Charlotte Department of Transportation

Memorandum

Subject: Rezoning Petition 08-060: Located on the east side of Point O'Woods Drive and the west side of Northlake Centre Parkway (Revised 5/23/08)

RZ-2.0

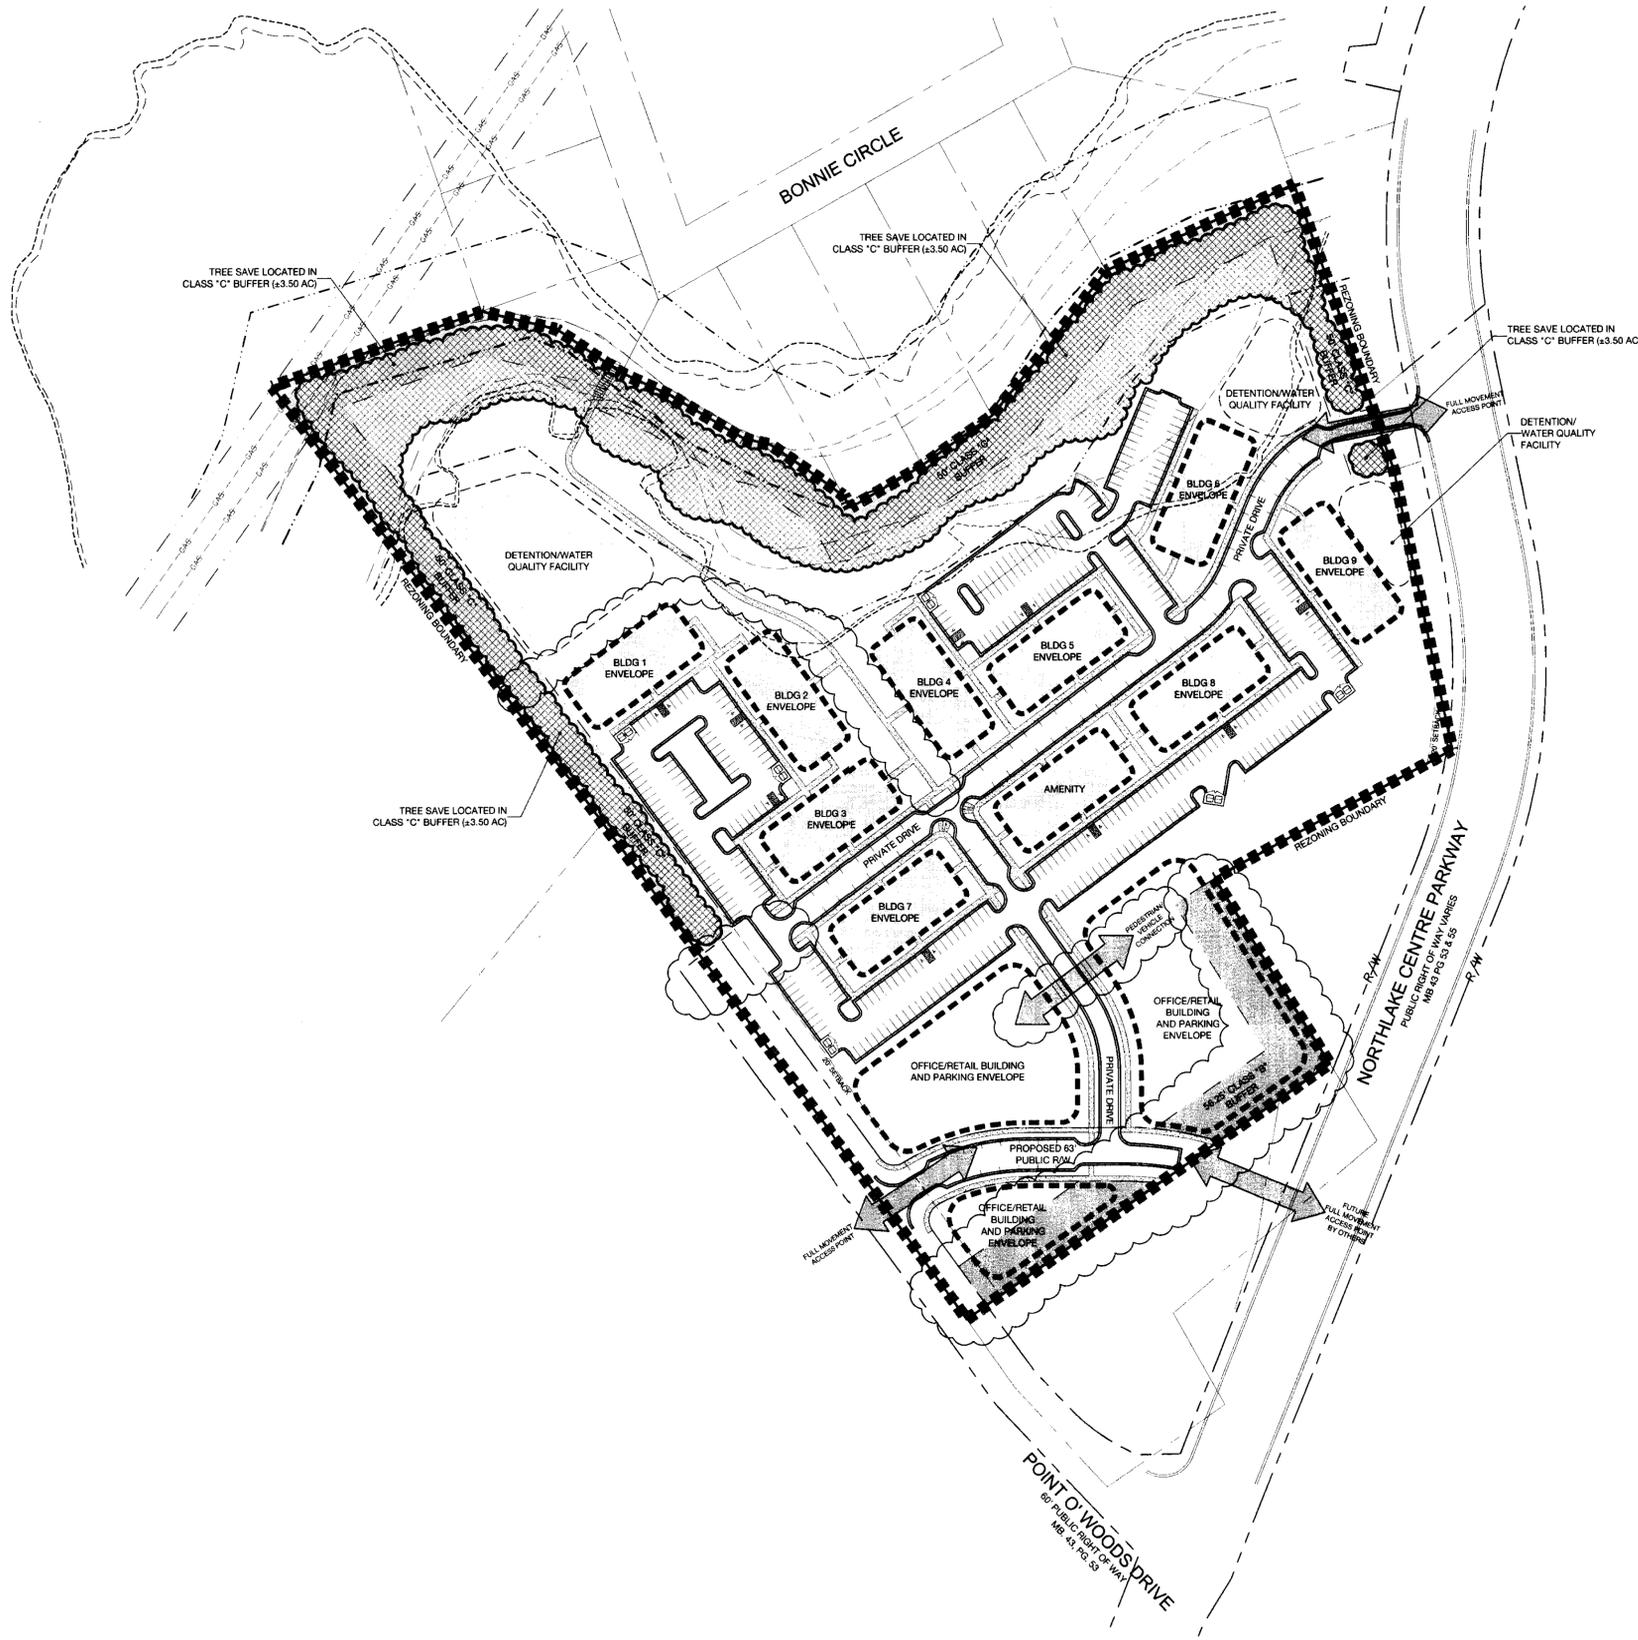
1. Upon extension of the proposed 63-foot right-of-way/street located on the south side of the site to Northlake Centre Parkway, the existing portion of Point O'Woods Drive between Northlake Centre Parkway and the southern stub to the Northcrest Shopping Center needs to be removed and a petition submitted to the City for abandonment. (*Previous review comment*)

2. A northbound left-turn lane must be constructed on Northlake Centre Parkway at the middle driveway to Northlake Mall to allow for U-turns into this site. The length (minimum 150 feet) will be determined in the traffic study. (*Previous review comment*)

3. A left-turn lane must also be constructed on northbound Northlake Centre Parkway at the northern driveway to Northlake Mall to accommodate the planned extension of main street through the development across the Faison parcel (undevelopable) to Northlake Centre Parkway. The traffic using the left-turn lane would be directly attributable to the development. (*Previous review comment*)
